# NORTH LEVEL DISTRICT INTERNAL DRAINAGE BOARD

**H02-0598-25**

**Proposed Residential Development Comprising 3 Detached Dwellings  
Land South of Barn Lodge Commercial Premises, Hereward Way, Crowland**

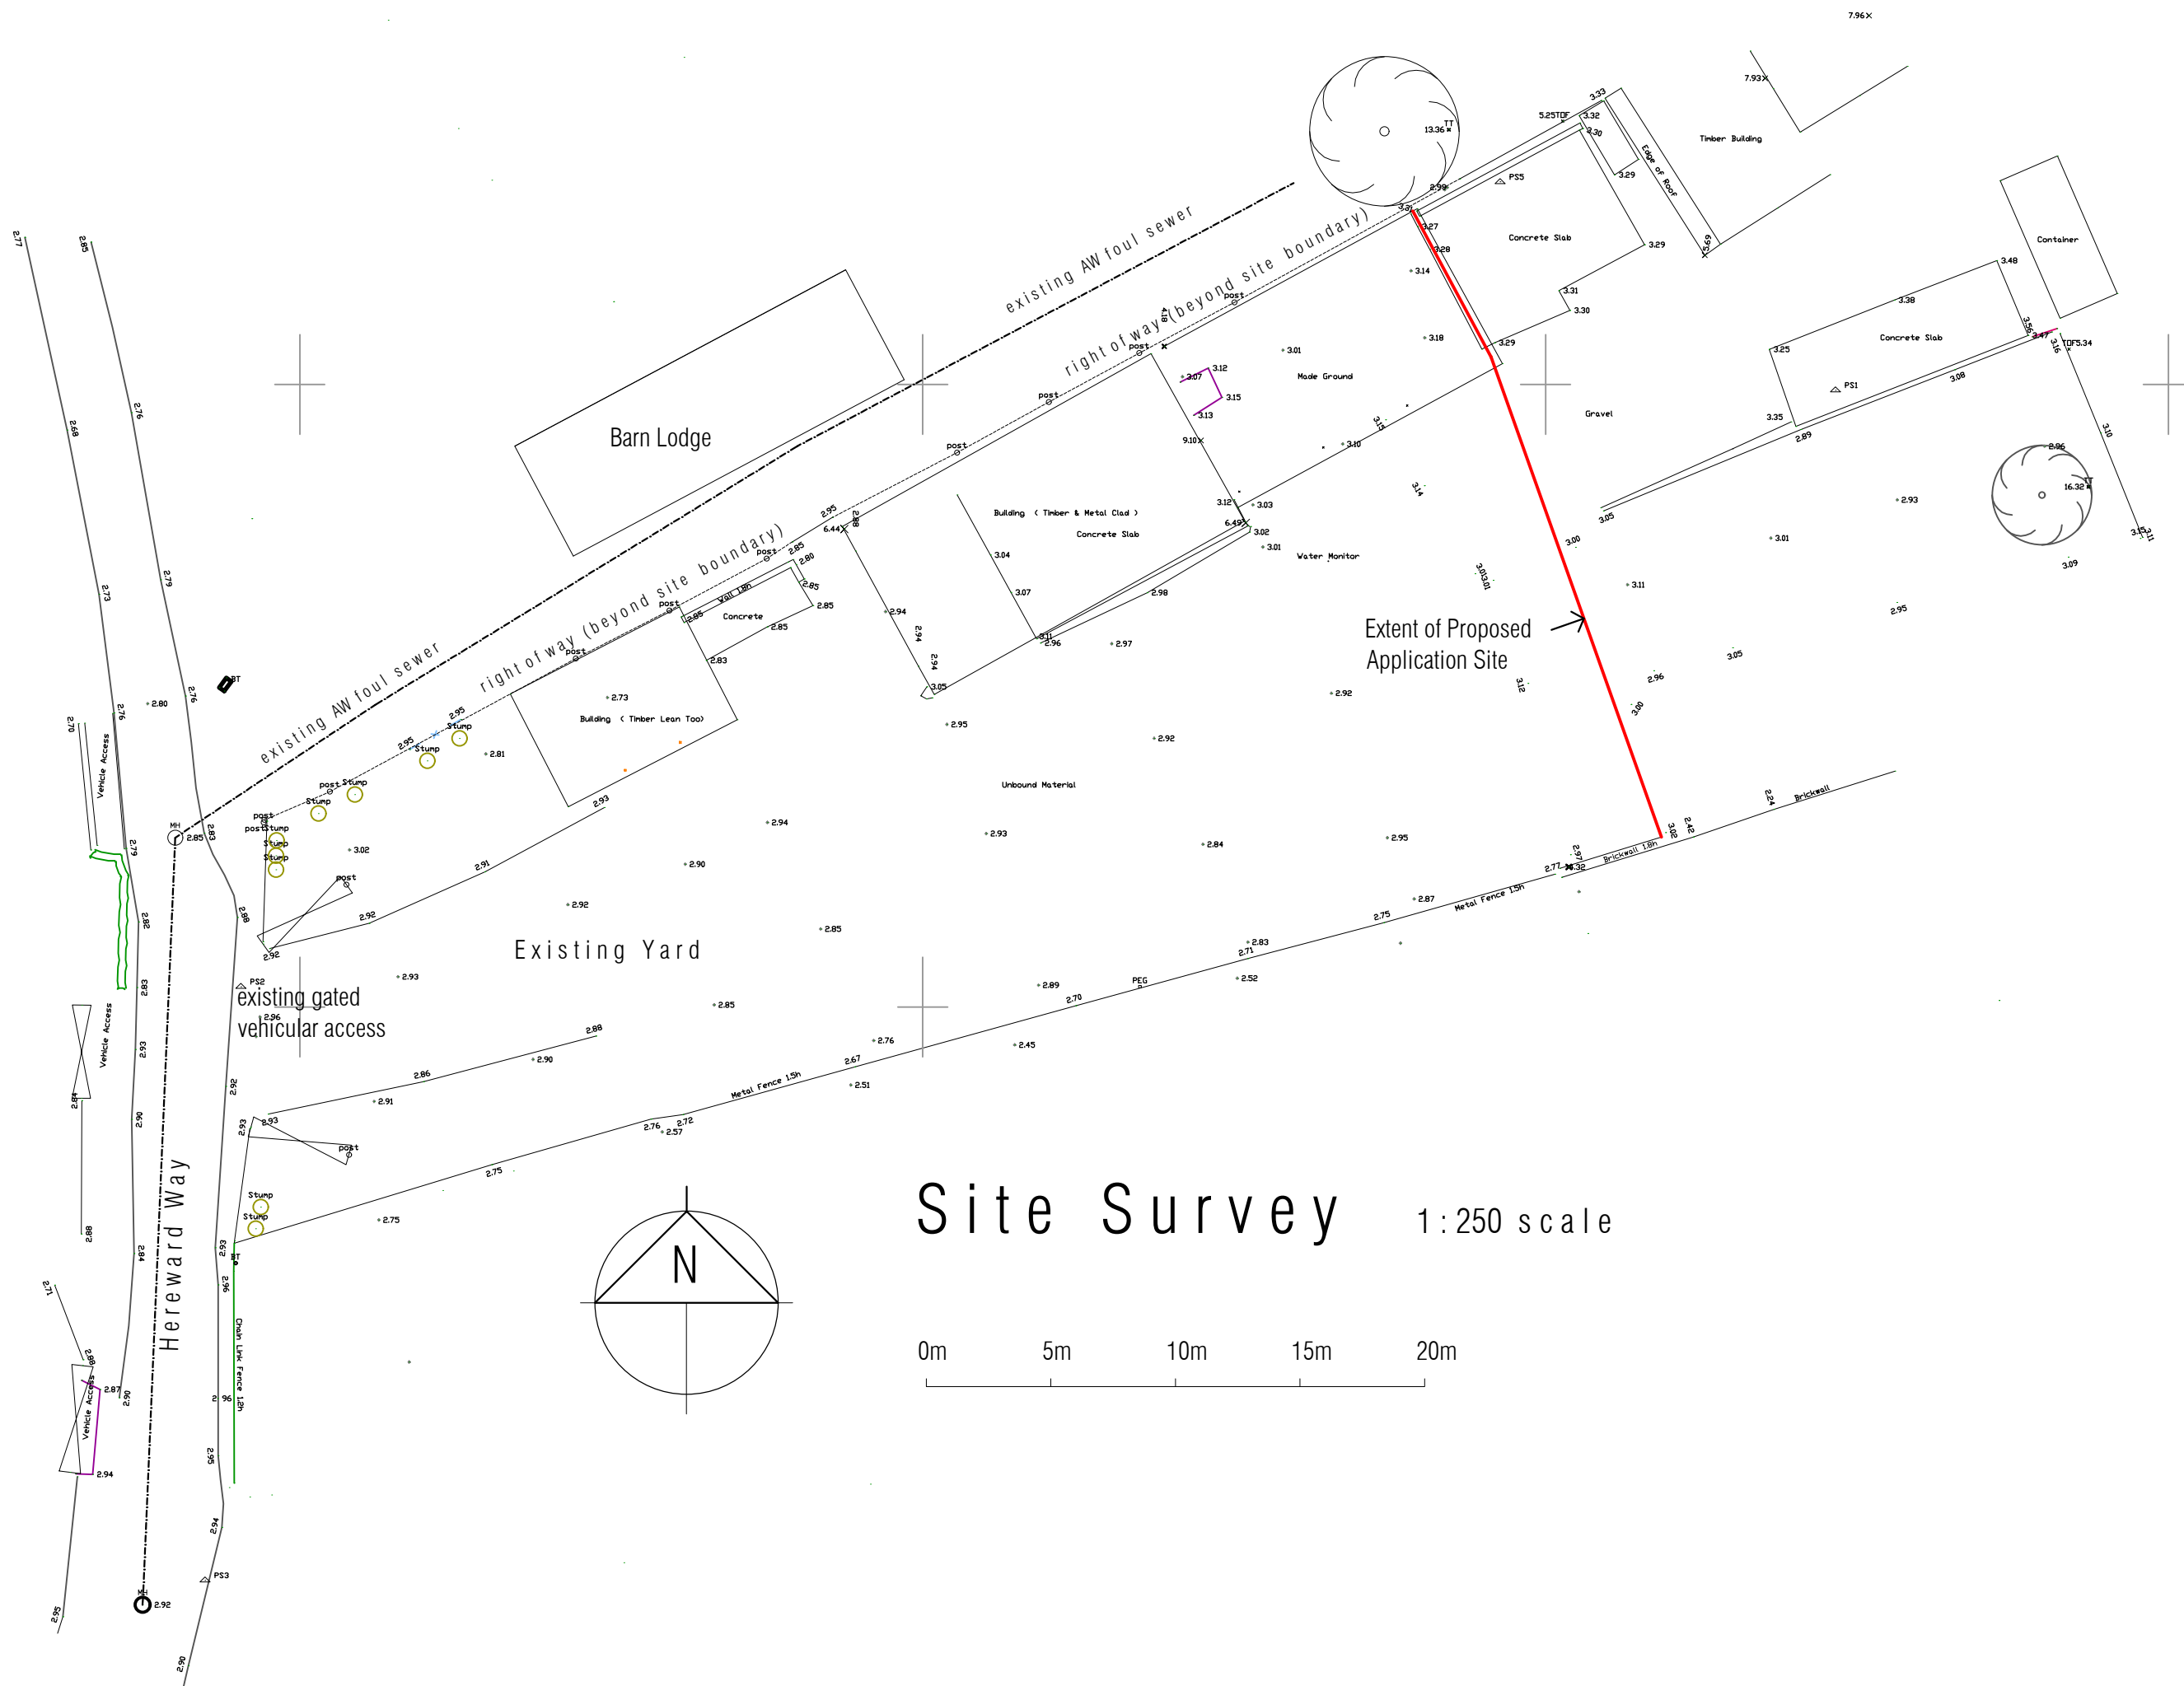
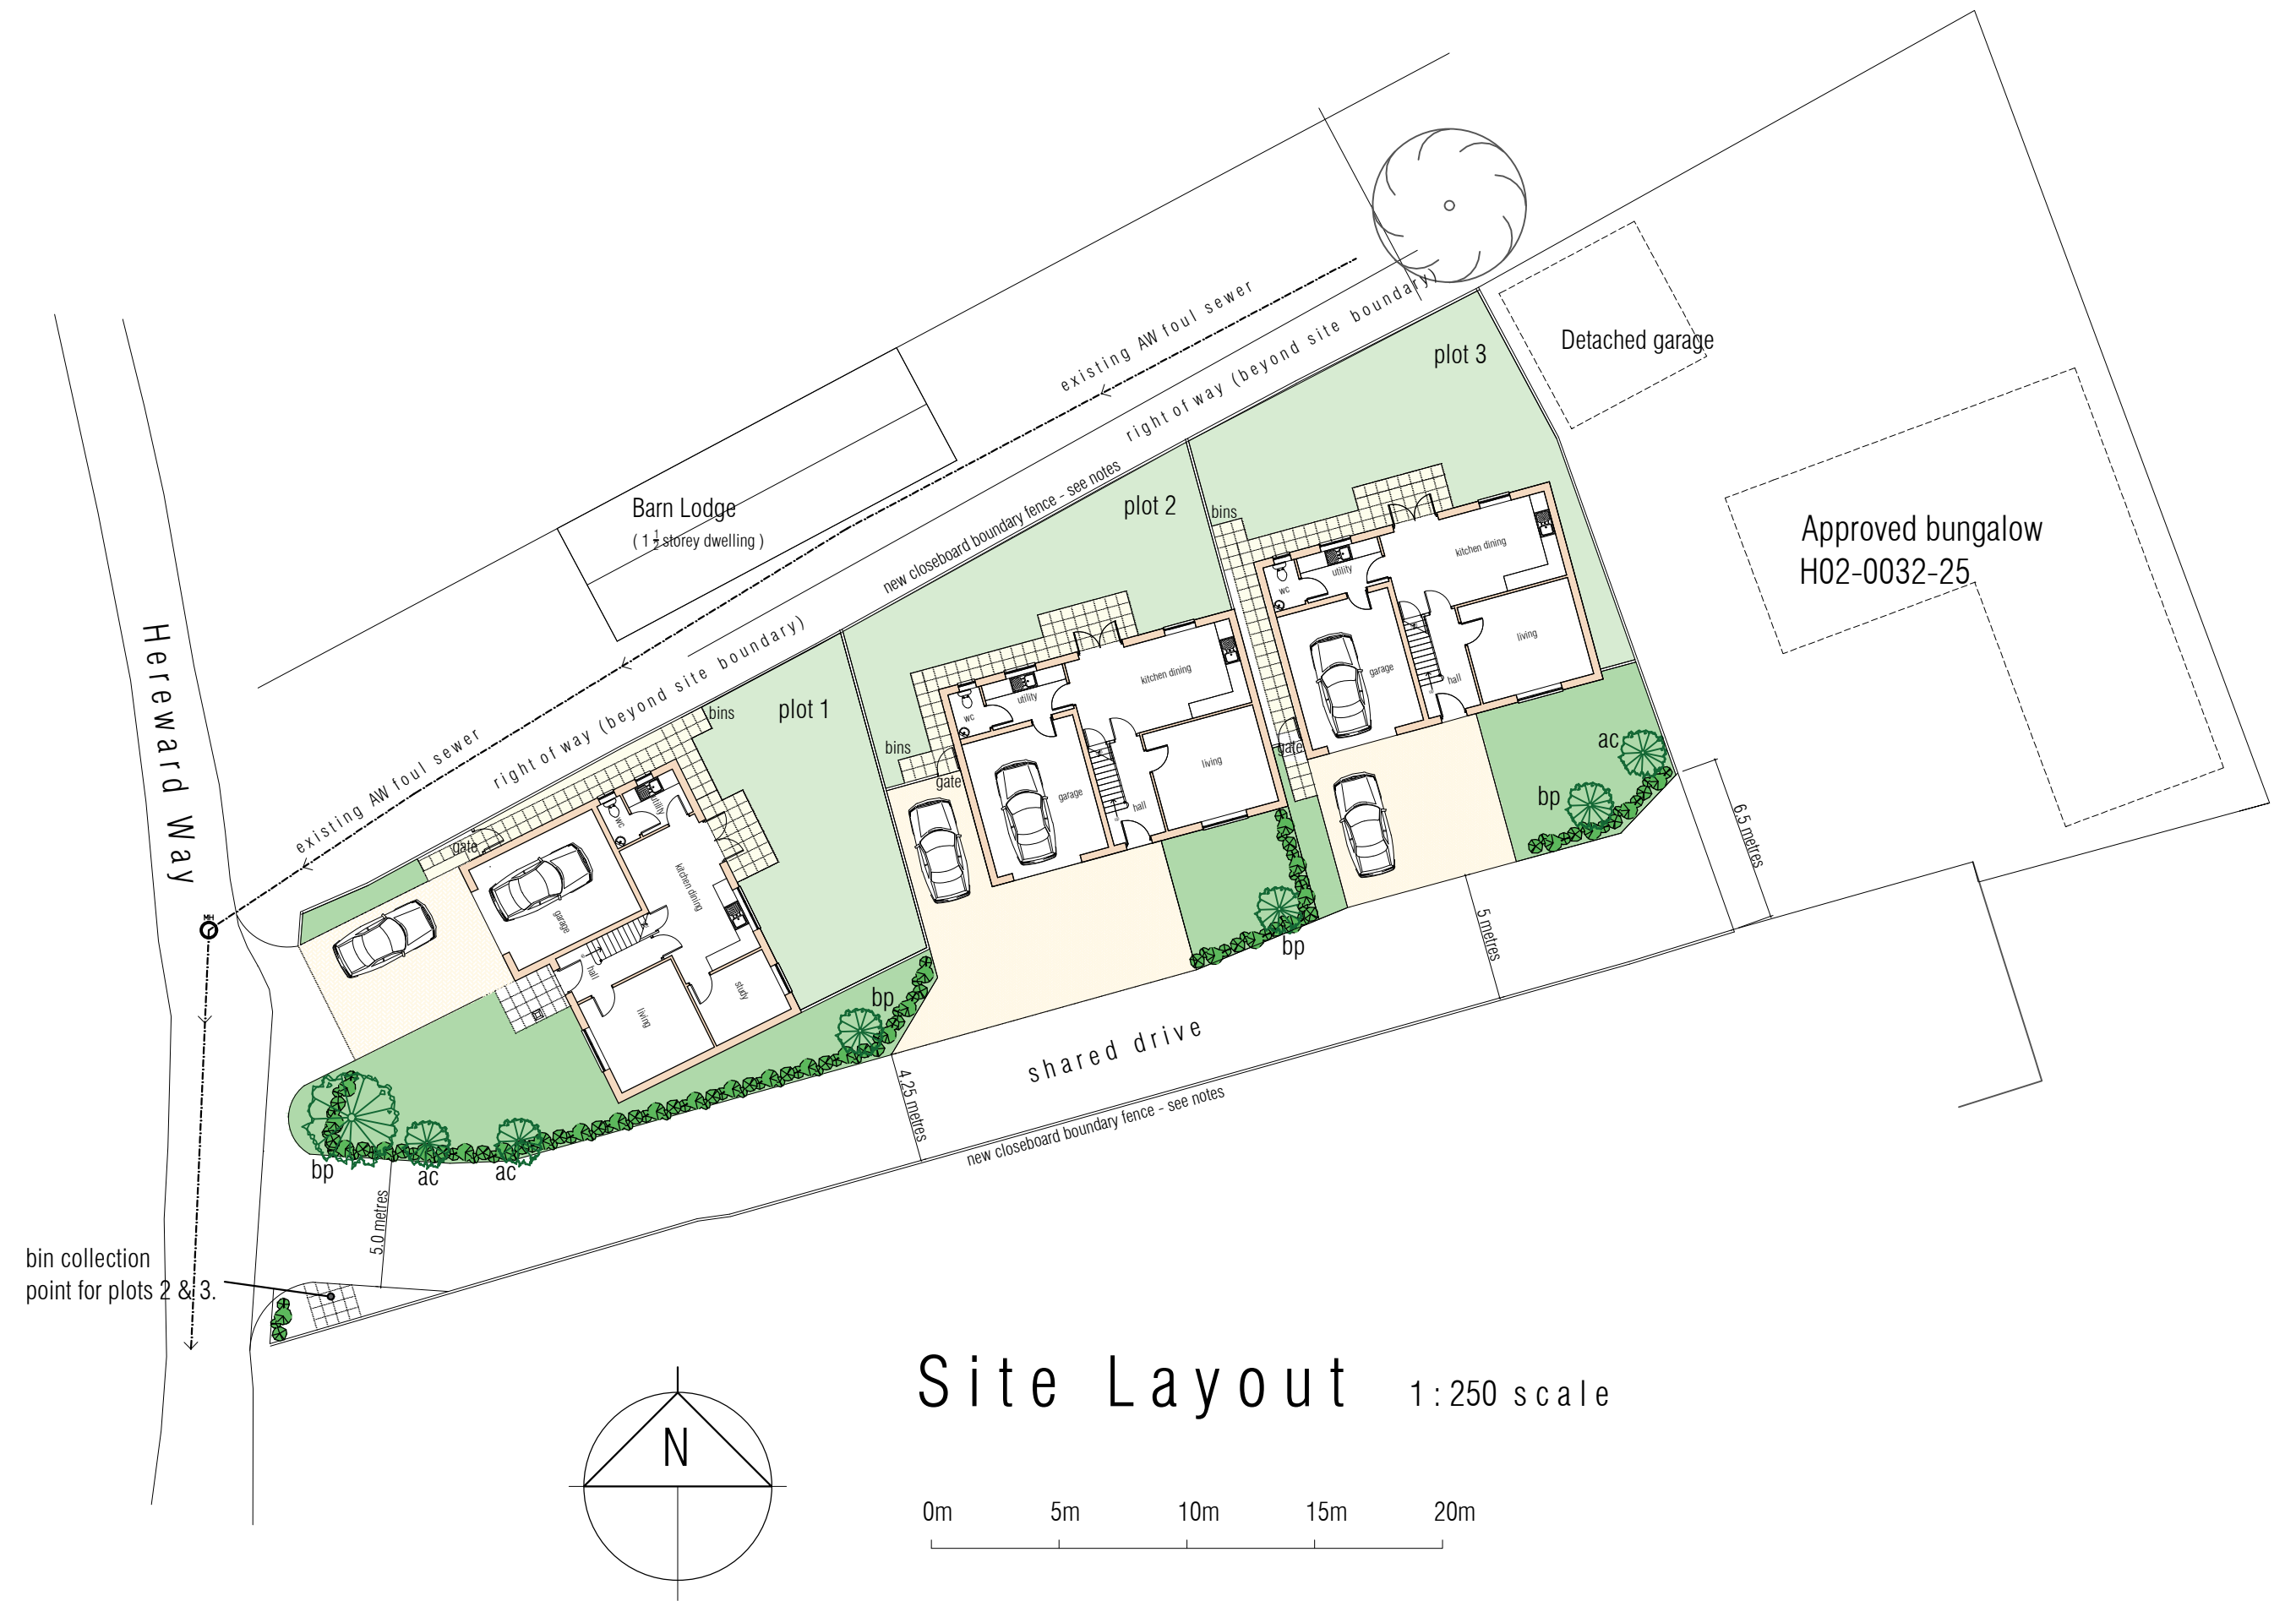
It is noted the application form says surface water will be discharged to soakaways, however, the position and size of the proposed dwellings may preclude the use of infiltration systems, or significantly limit design and layout options for these, as standard requirements mean they need to be a minimum distance from development.

If soakaways prove to not be suitable, and the proposals will instead result in an increase in the rate and/or volume of water being discharged to a watercourse, an application seeking consent from the Board will be required. If such an application is consented, a development levy would be payable in accordance with the enclosed.
